Hinckley National Rail Freight Interchange

Burbage Deadline 3 – Response

Burbage Parish Council Written Presentation

Full Input Data And Results

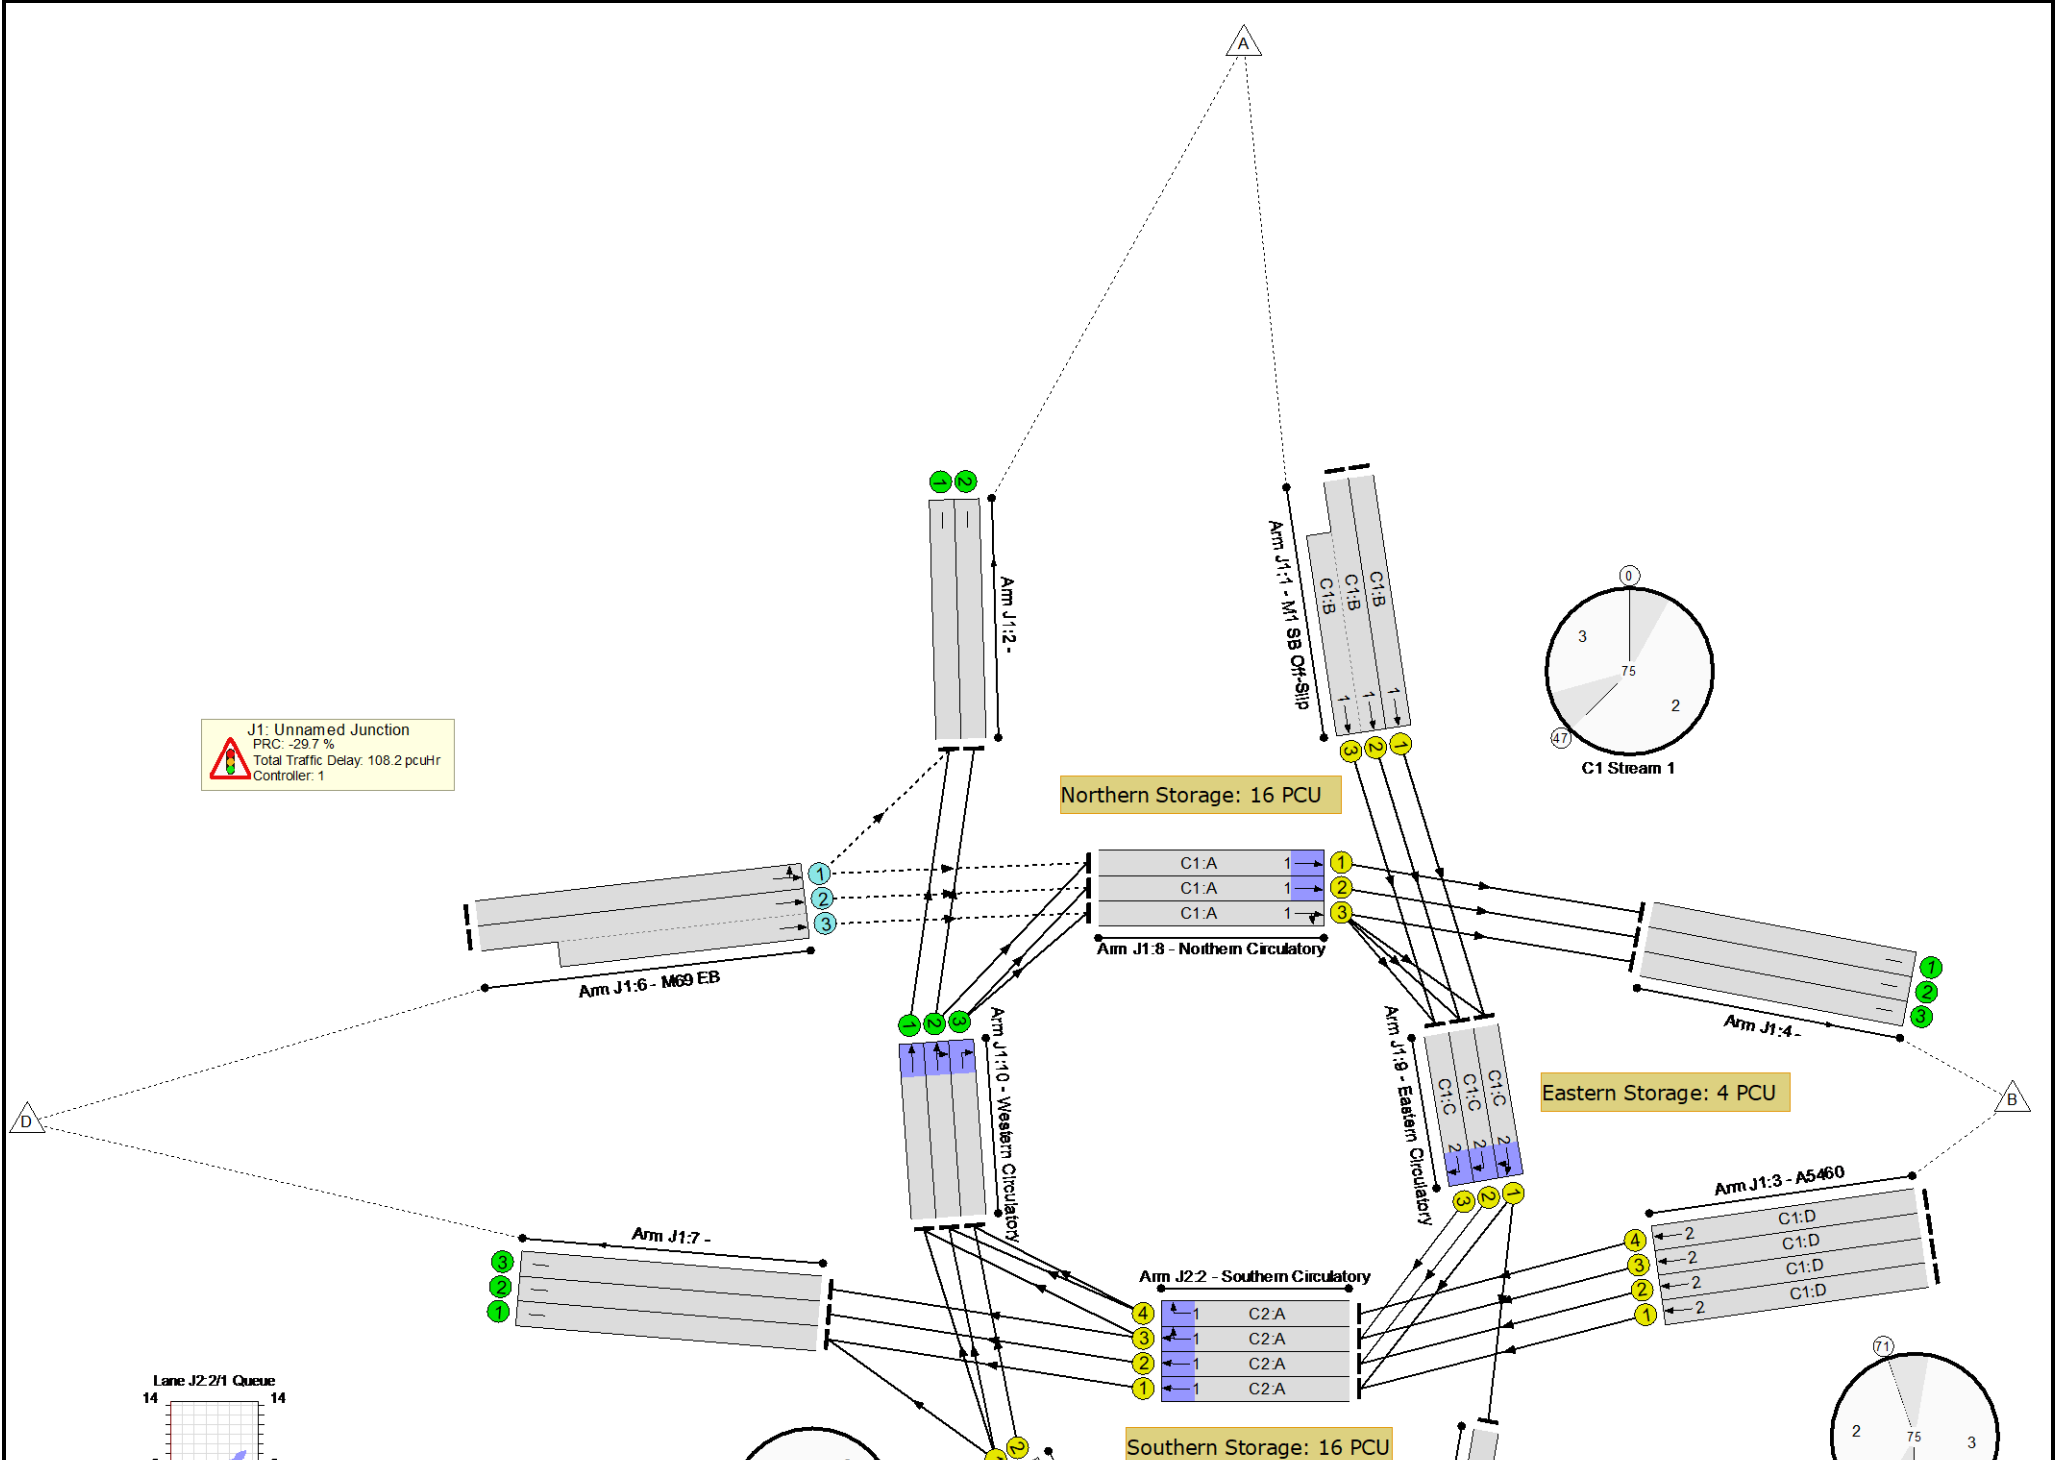
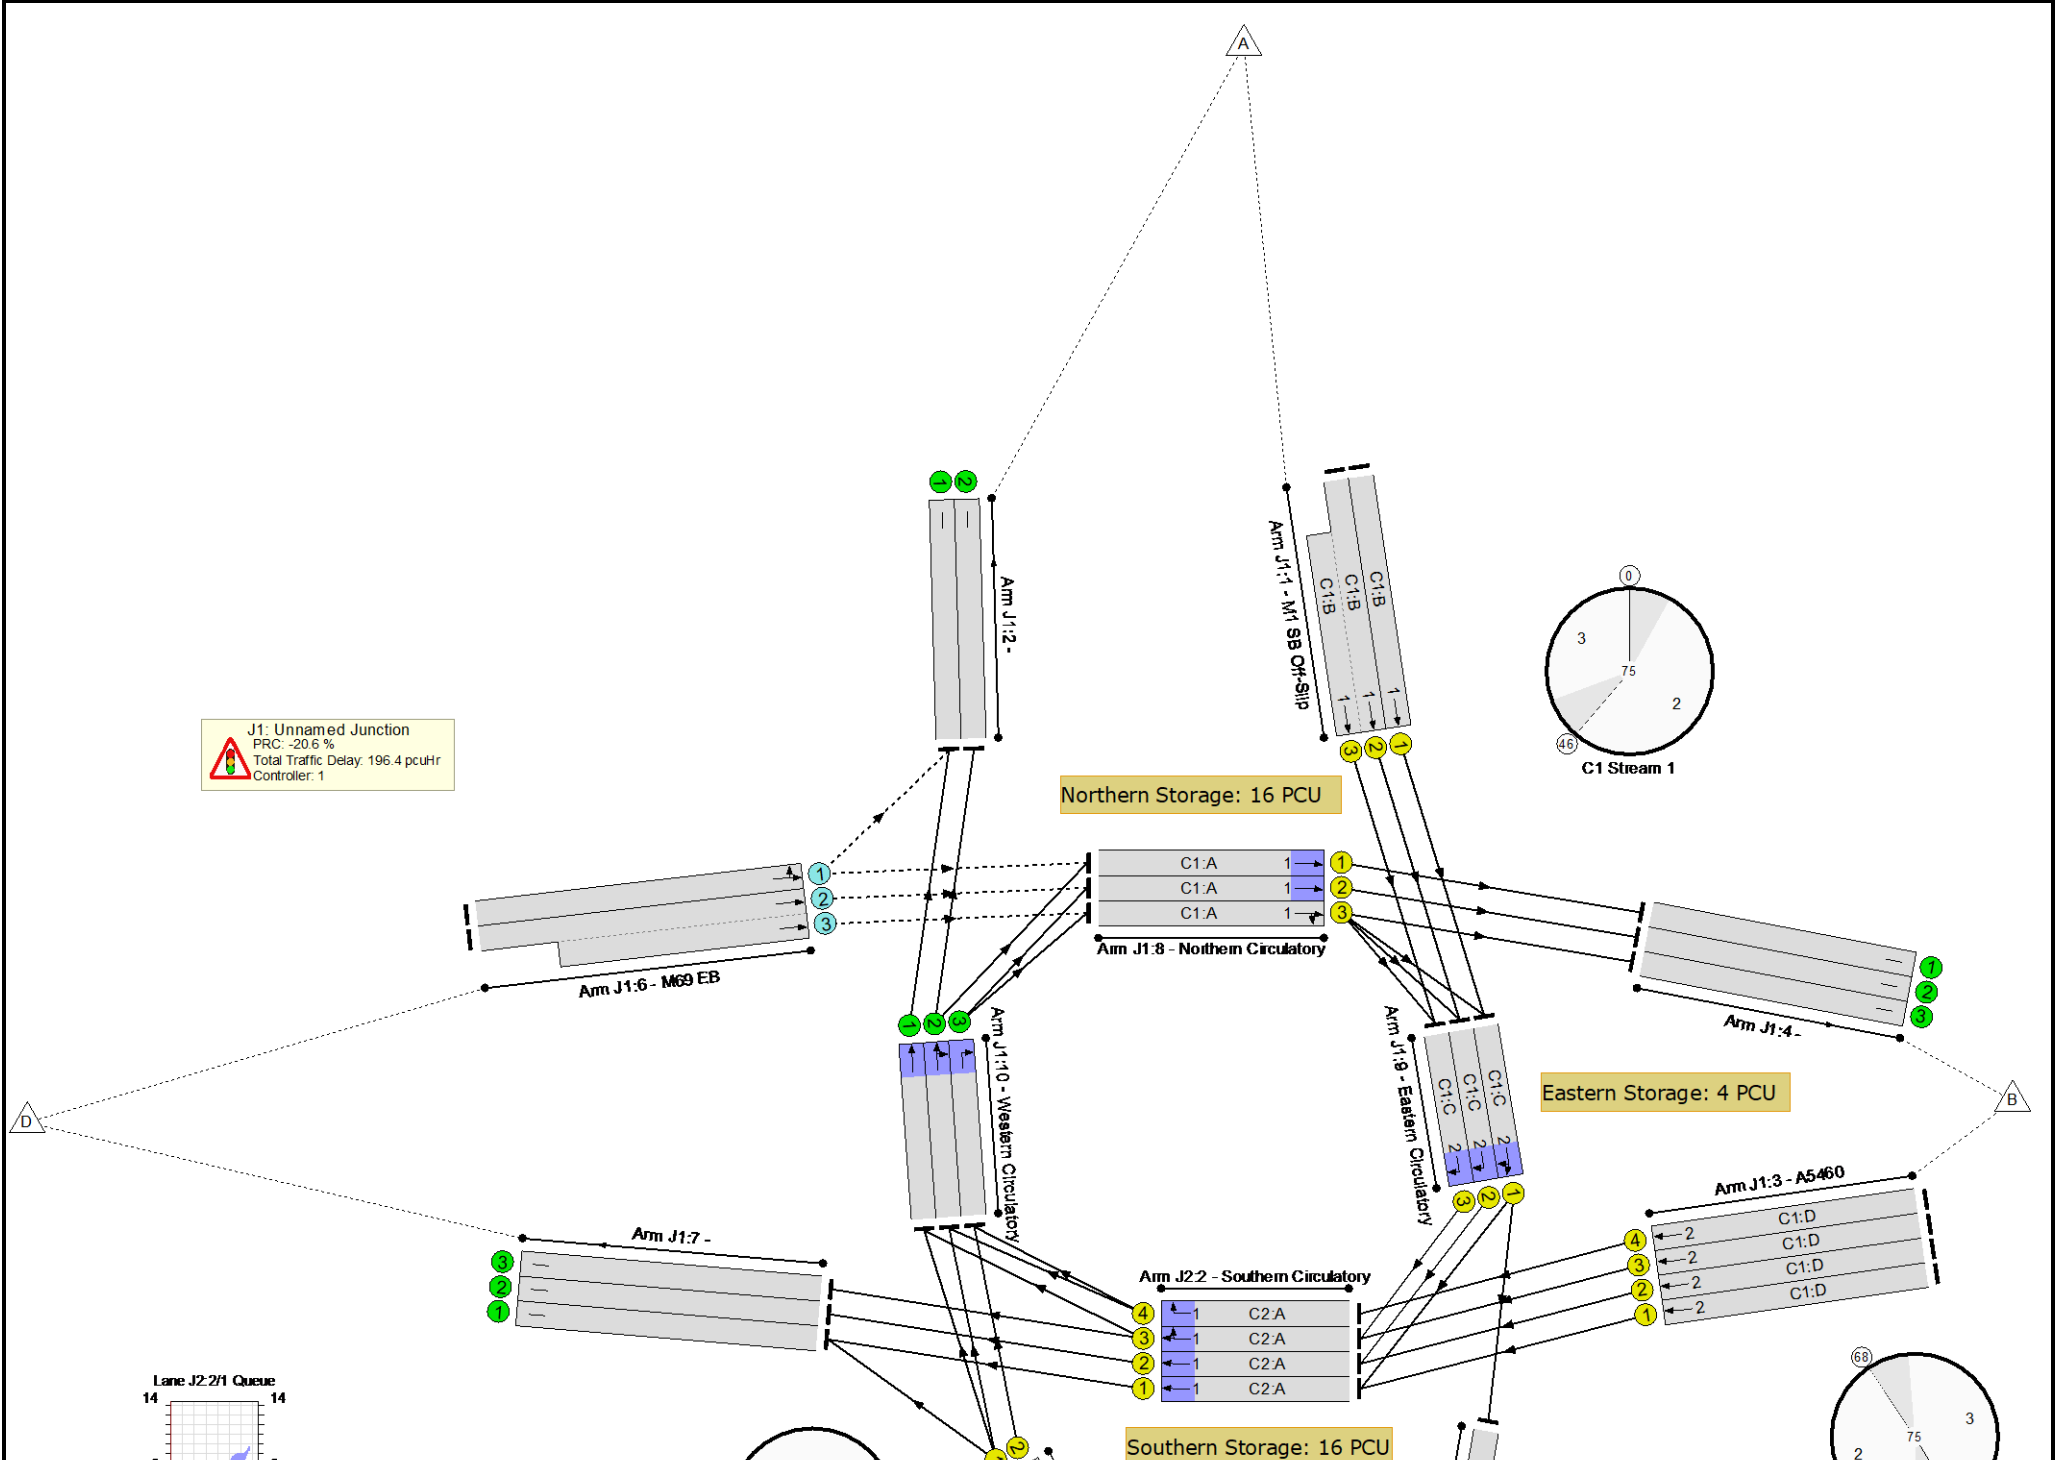
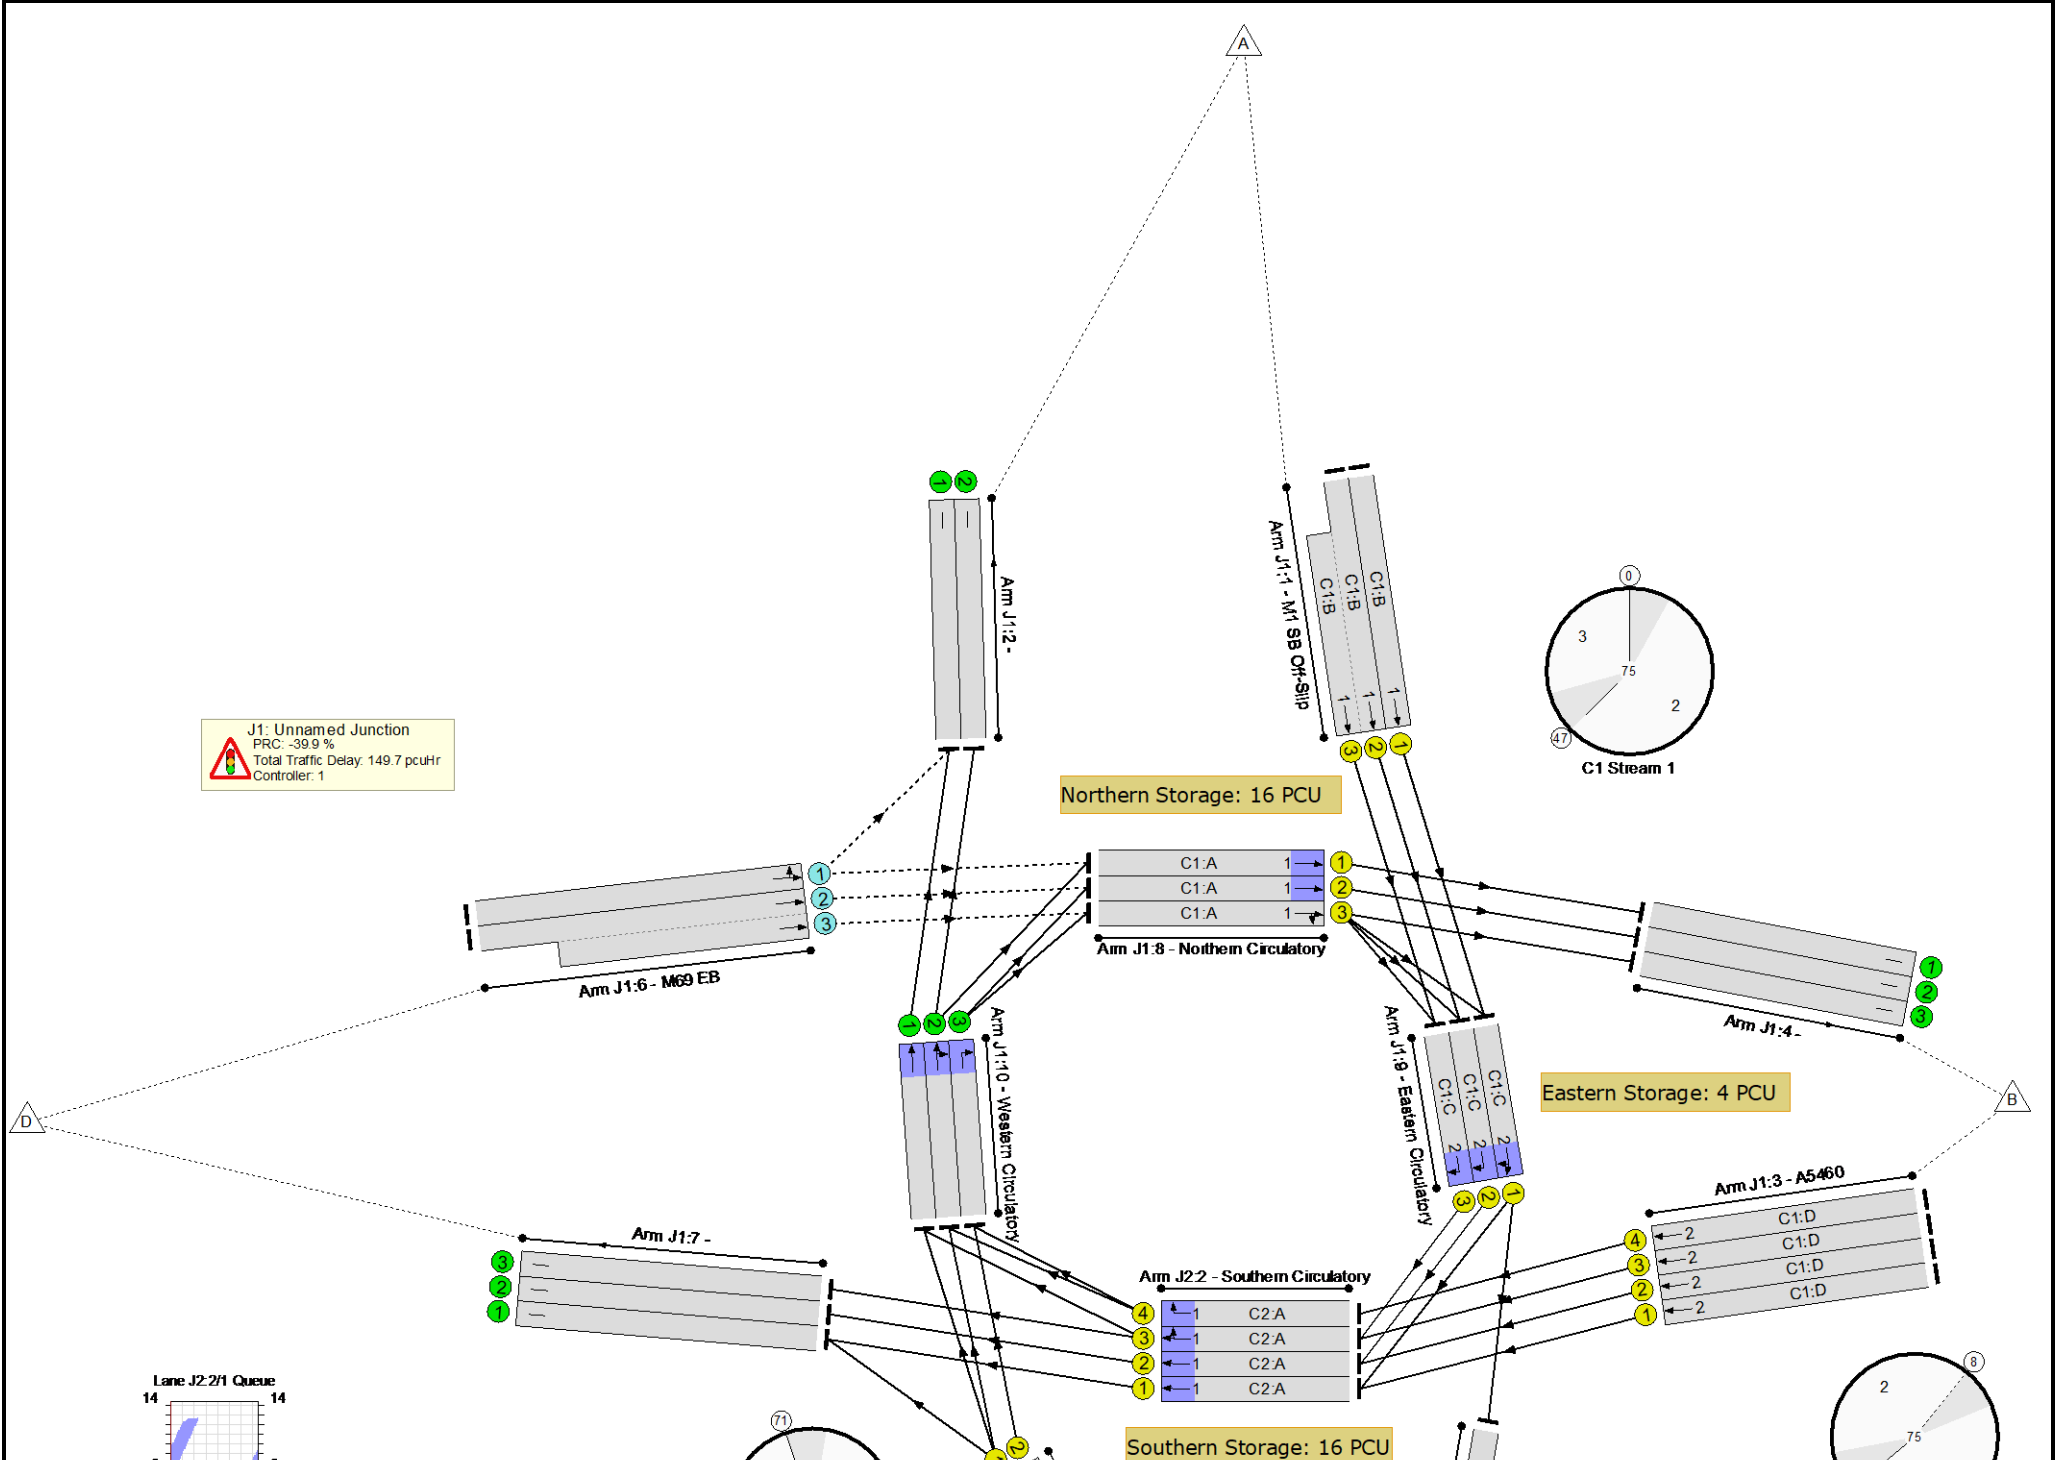
M1 Junction 21/ M69 Junction 3

We were appalled to hear at ISH2 that Tritax Symmetry have taken the view that they do not have to submit **any** mitigations for this junction due to the additional traffic from the development. Our understanding from the hearing was that given the junction is at capacity and that development HGV traffic heading North will be mandated to use the M69 and this junction which will have severe delays, due to operation of the junction above the capacity. The effect in the modelling is that local

traffic (including non-development HGVs) will see extended delays at the junction and will therefore use the local road network to achieve a route into Leicester or the North bound routes.

If our understanding of the discussions at the hearing are correct, this will add a further, previously not discussed, impact on the local road network and the ability of our local community to go about their normal activities.
